Woollahra
Municipal
Council

16 December 2010

**Scottish Hospital 74 Brown Street (aka 2 Cooper Street), Paddington
Submission to Seniors Living Project Application**

04 PROPOSED SECTION F-F
OLD 'SCOTTISH HOSPITAL' BUILDING
1:100@A1

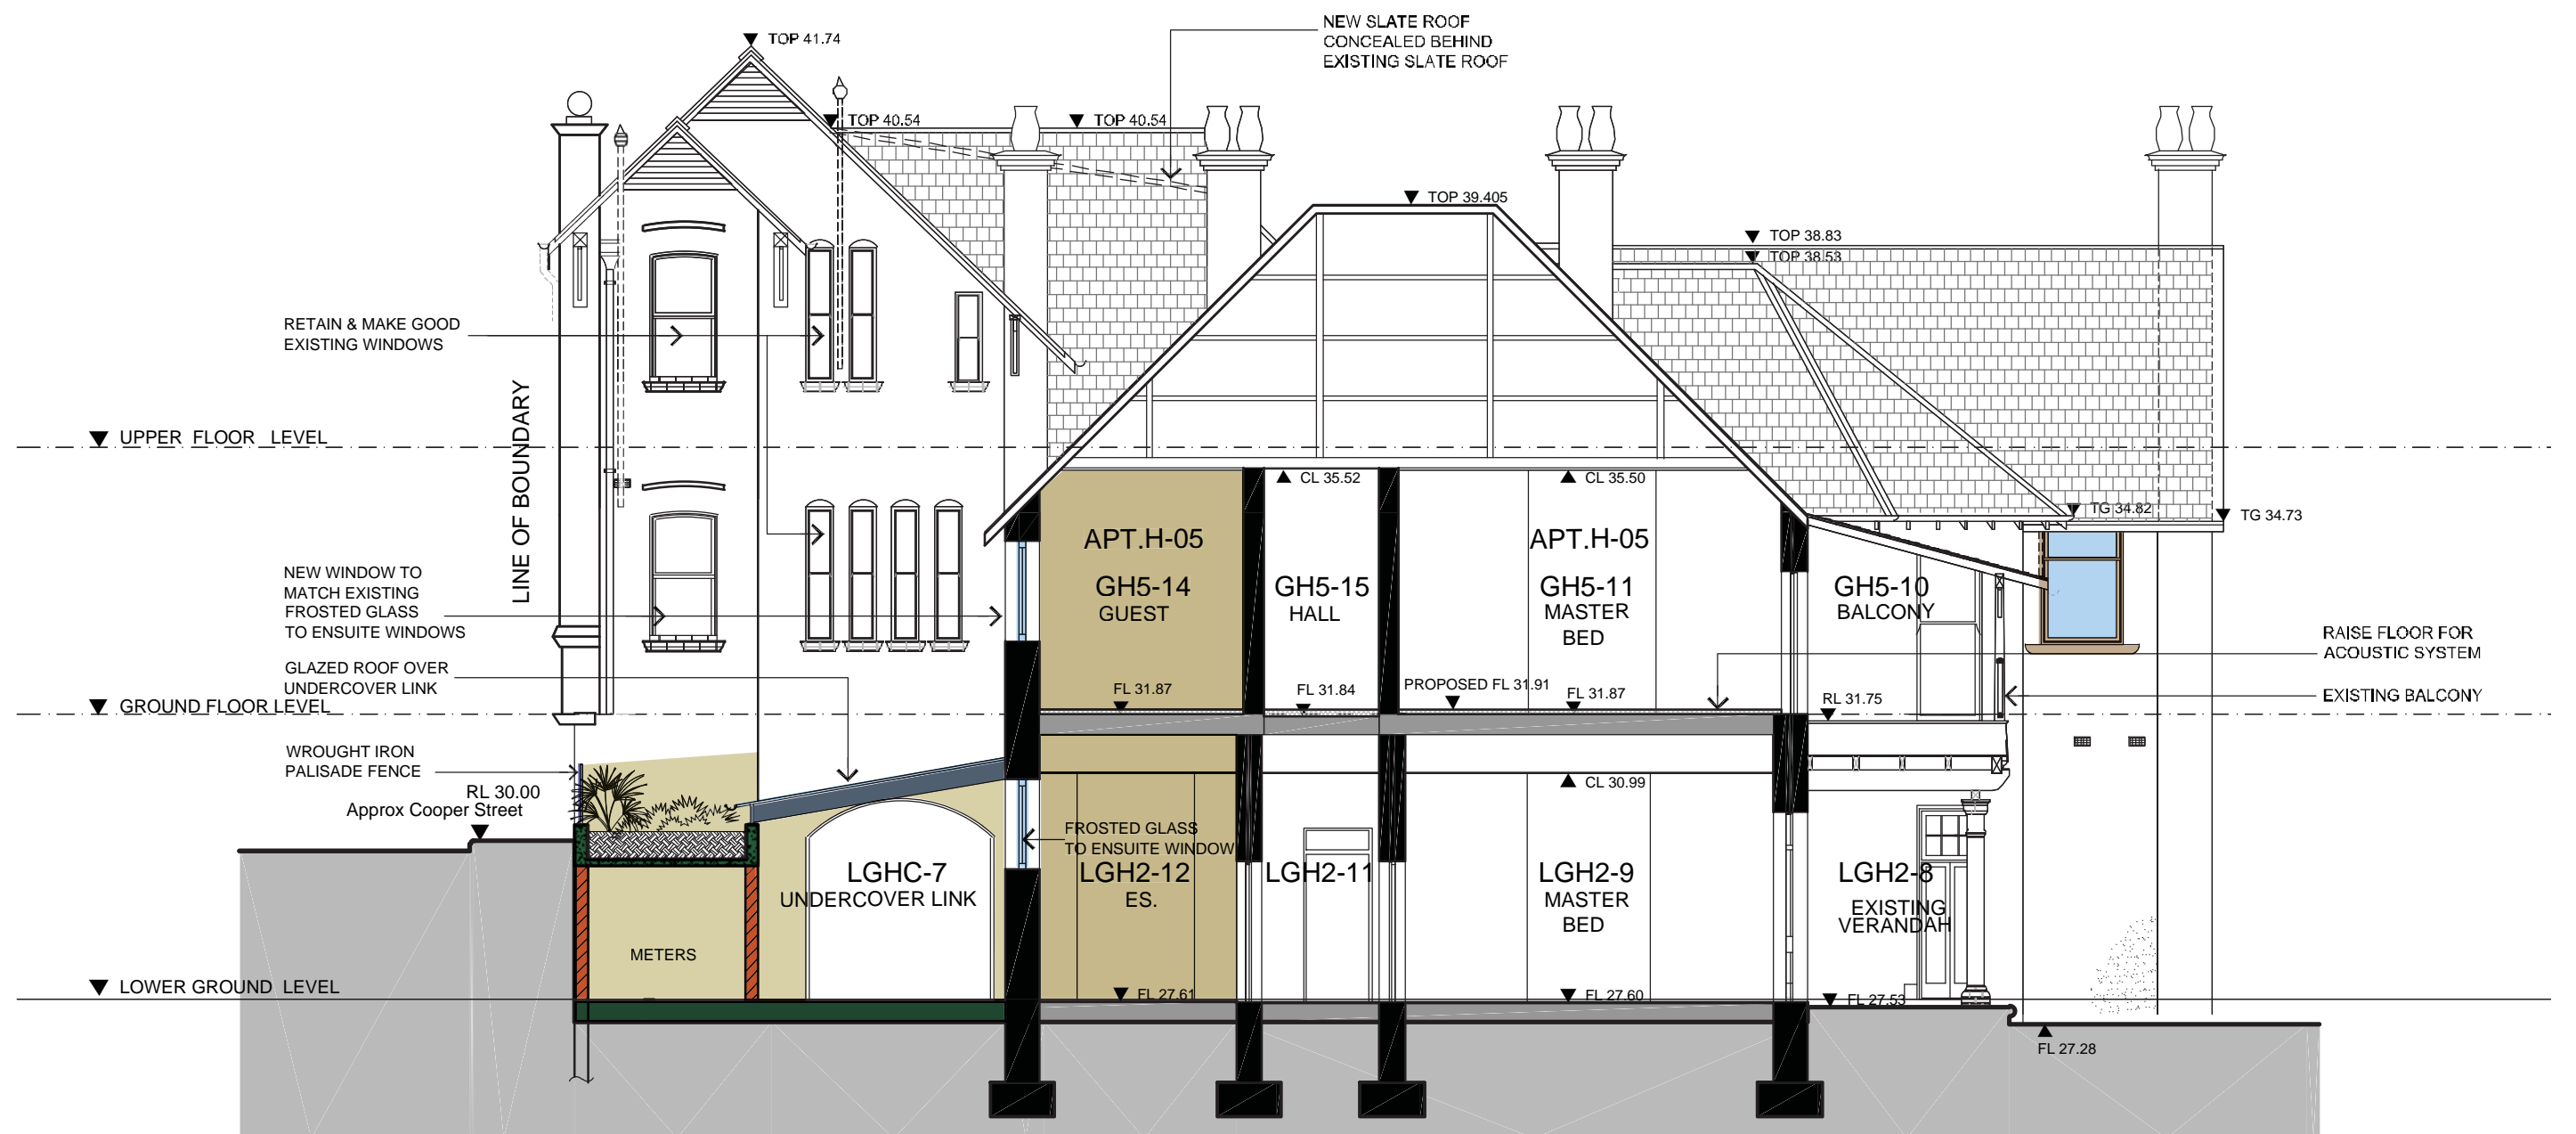
5. *The alterations to the roof level of the heritage listed Scottish Hospital building, as recognised by the NSW Heritage Inventory and the Woollahra Local Environmental Plan 1995, will unacceptably reduce that building's heritage significance.*

19 Cooper Street Balcony RL 36.95 Existing

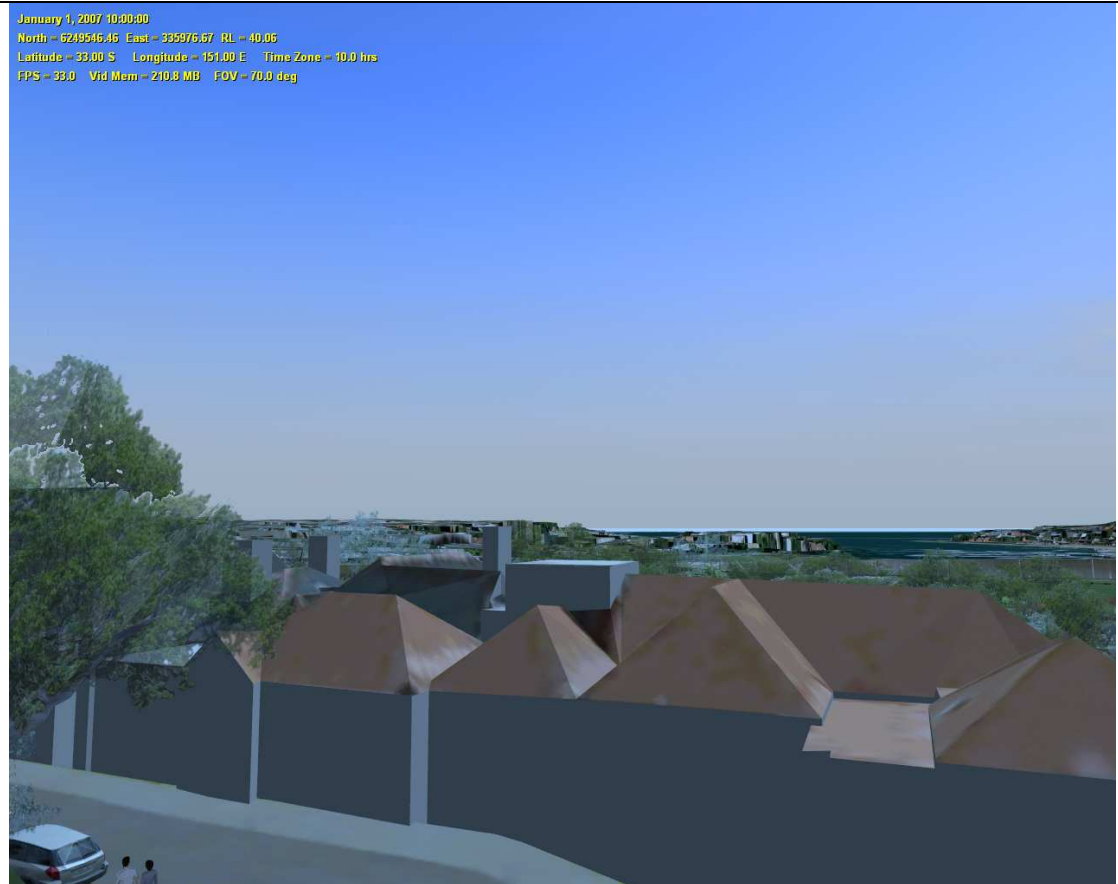
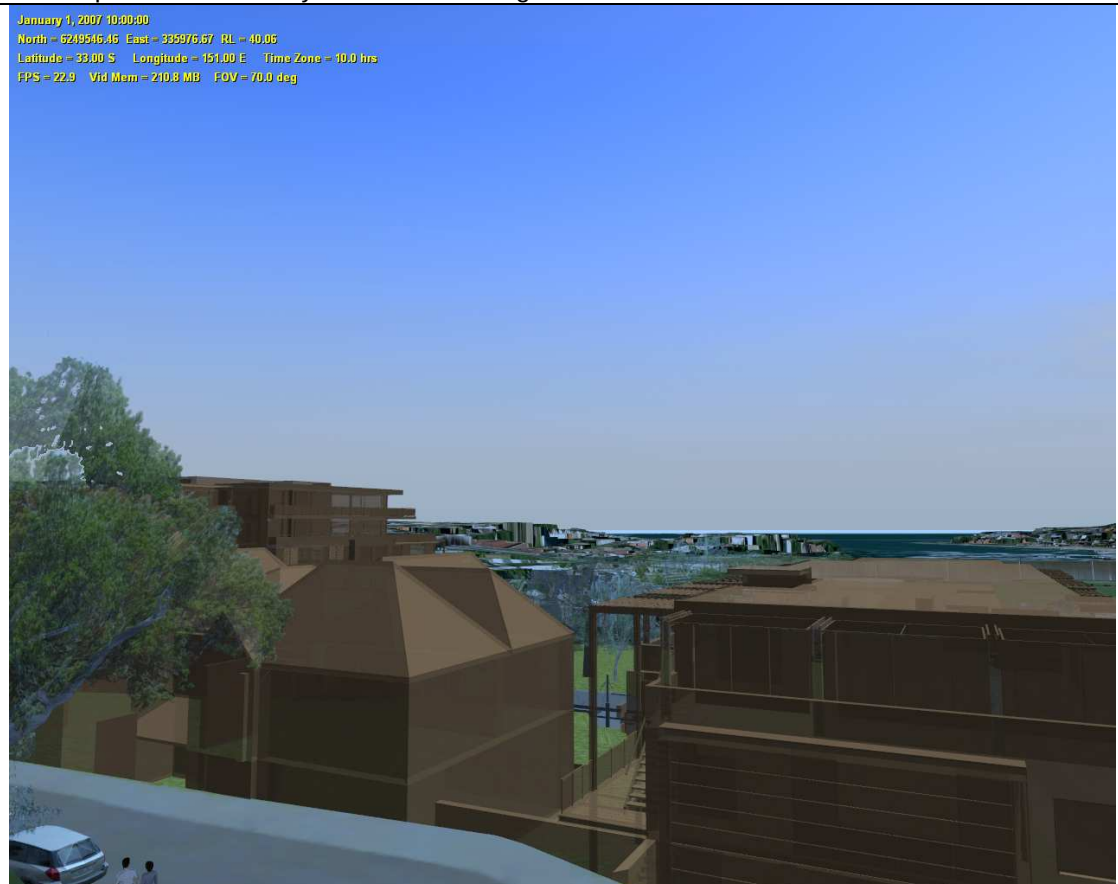
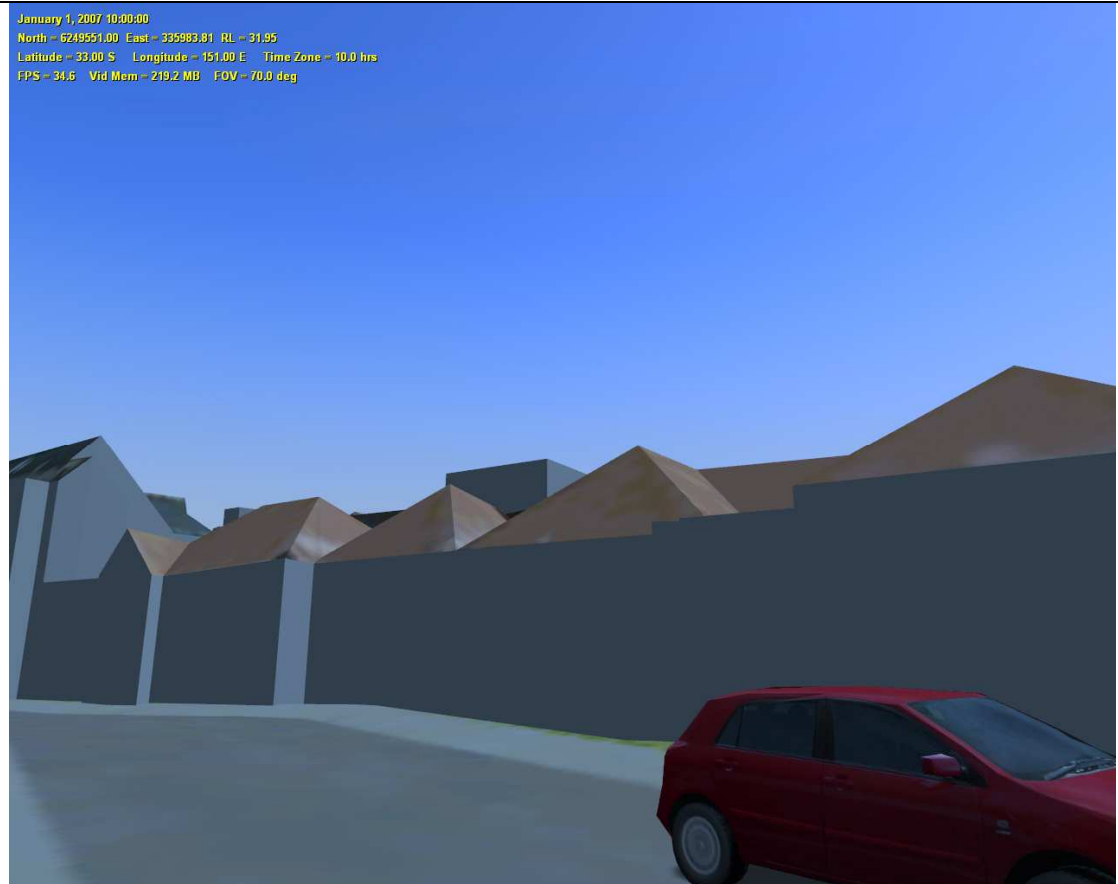
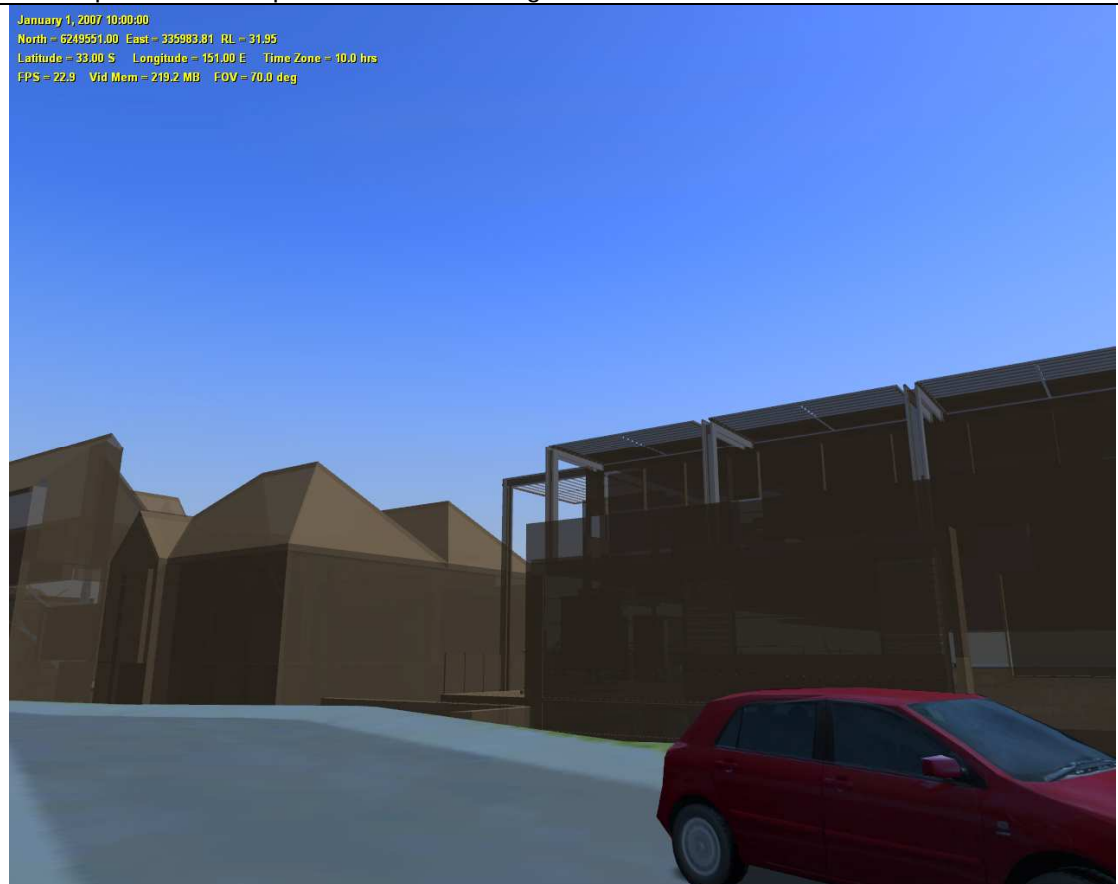
6. *The excessive height of the building referred to as the Brown Street Independent Living Unit building will cause an unreasonable impact on views from private properties on the southern side of Cooper Street.*

Section 2 - Traditional garden terracing

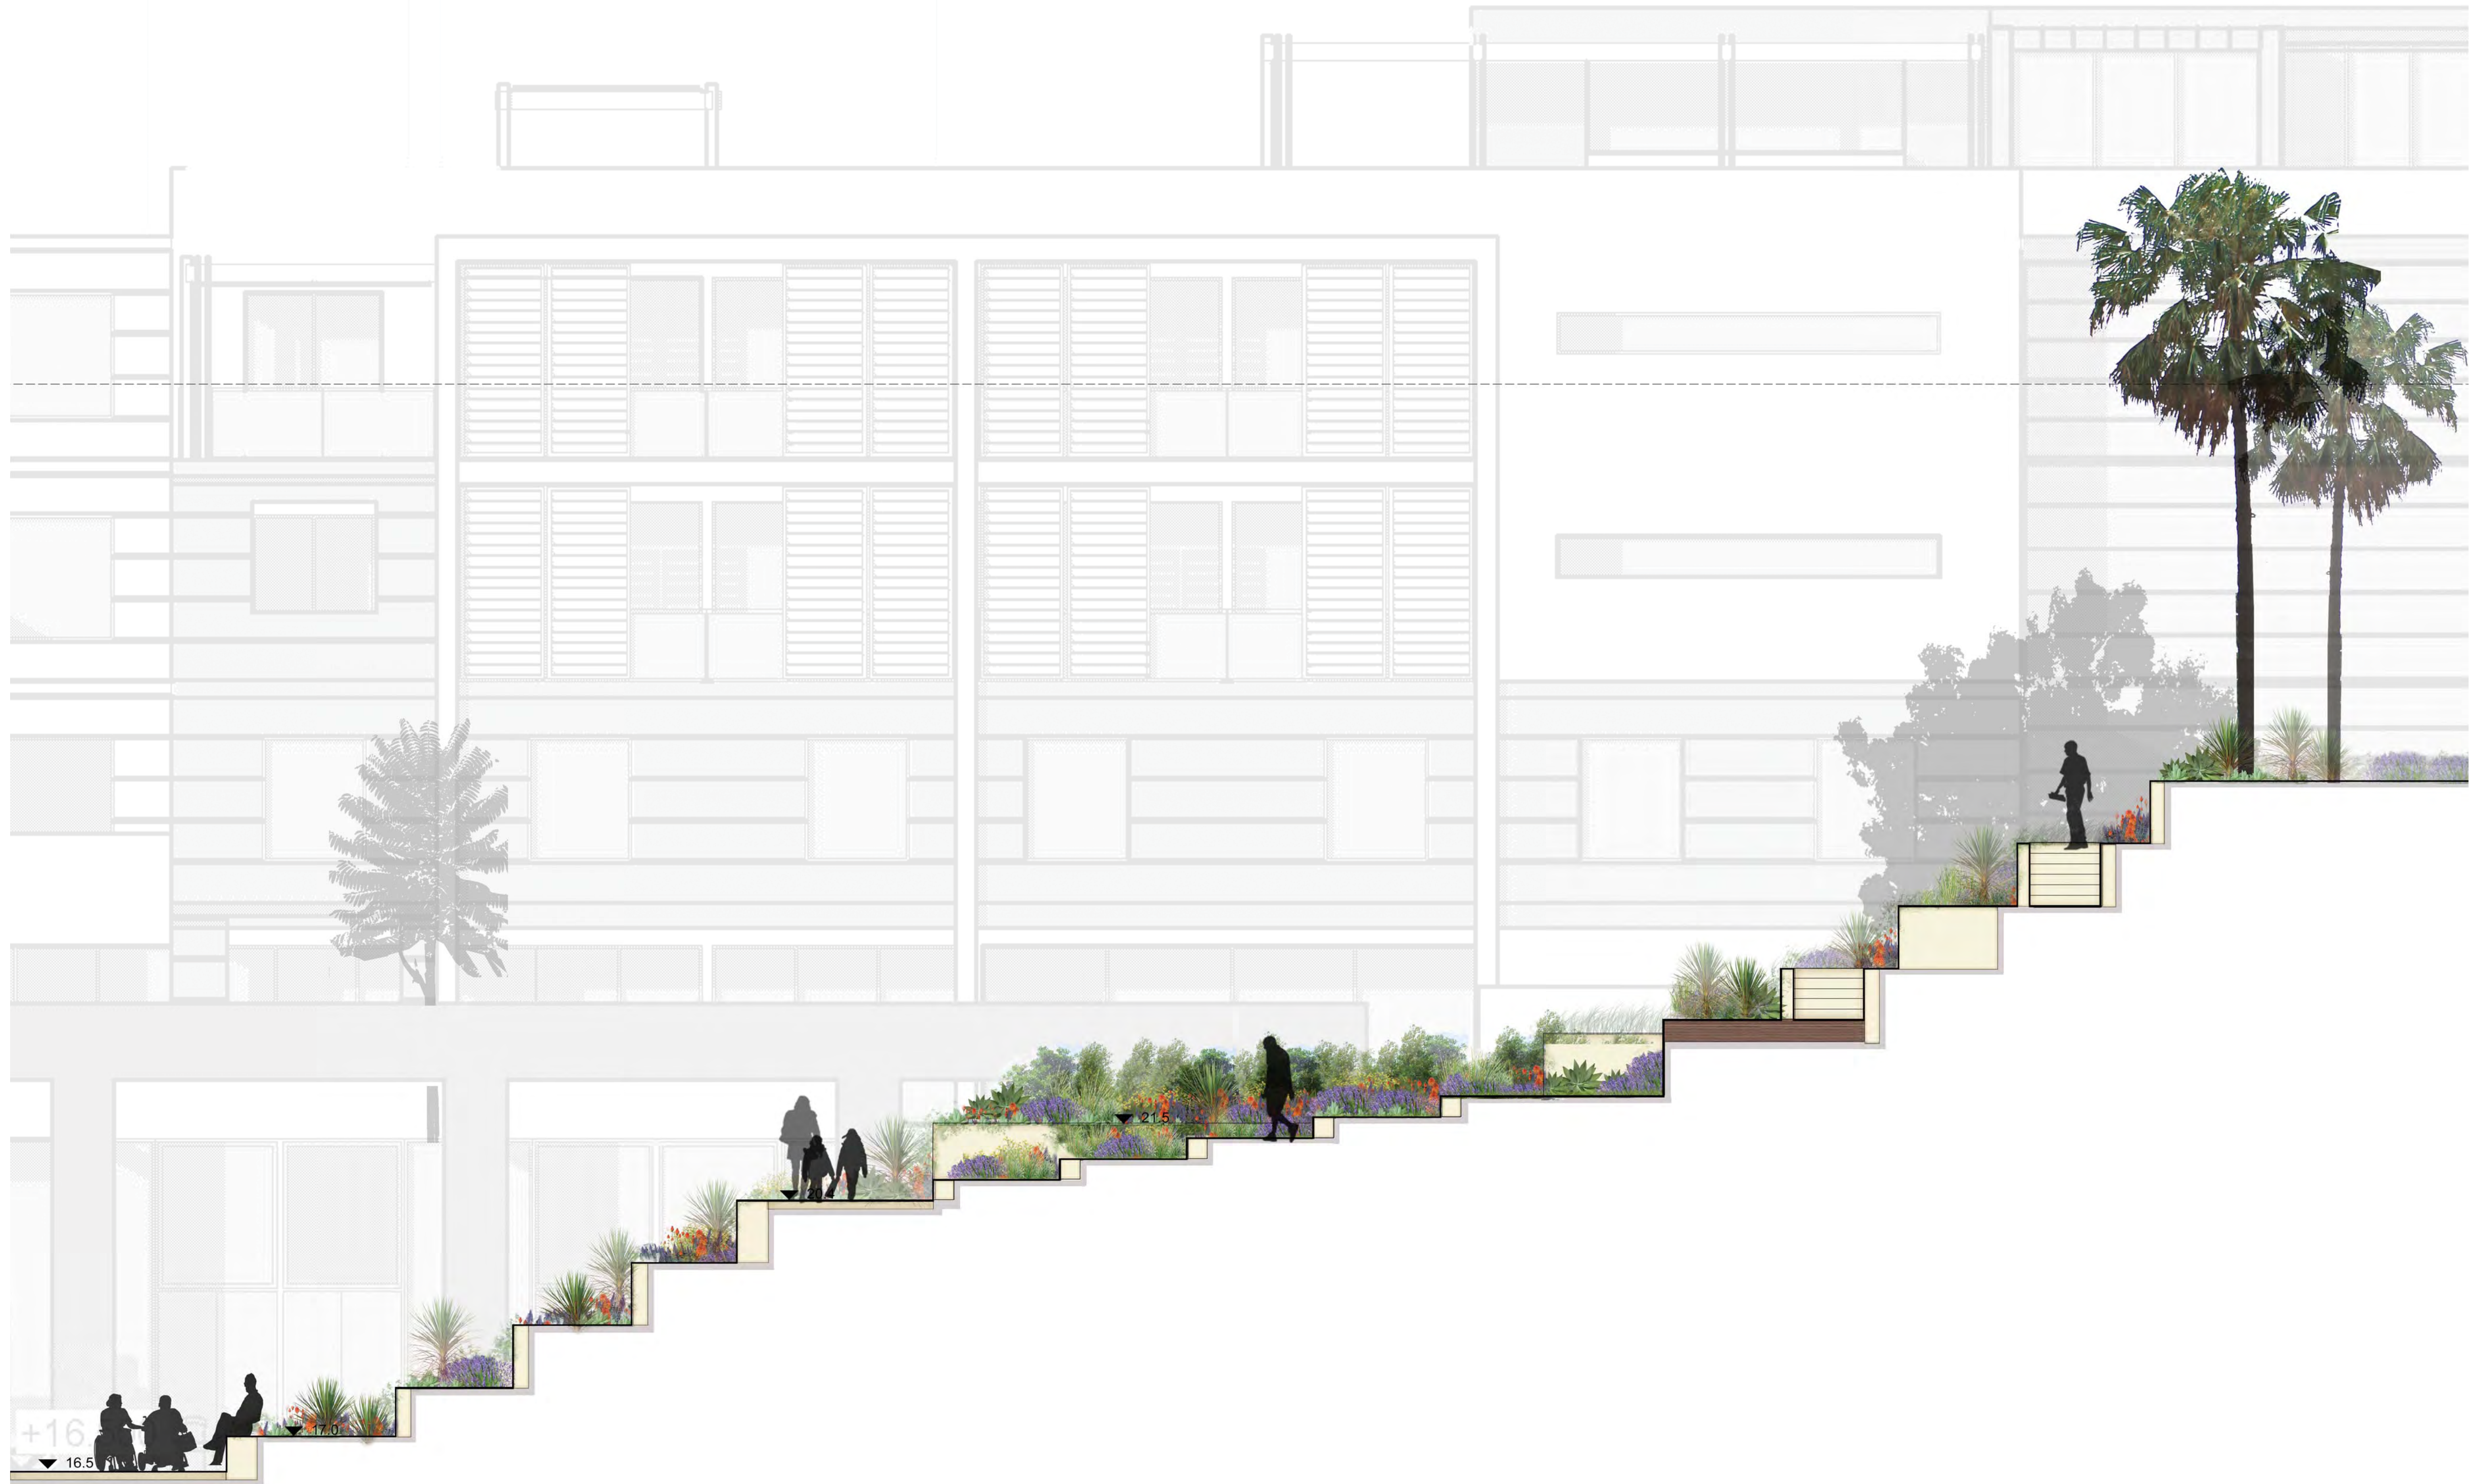
14. *The heritage terraces will be privatised with the top lawn area being only accessible to the occupants of the proposed adjoining apartments. There also appears to be no proper heritage based justification for the proposed from in which the terraces are being reinterpreted.*
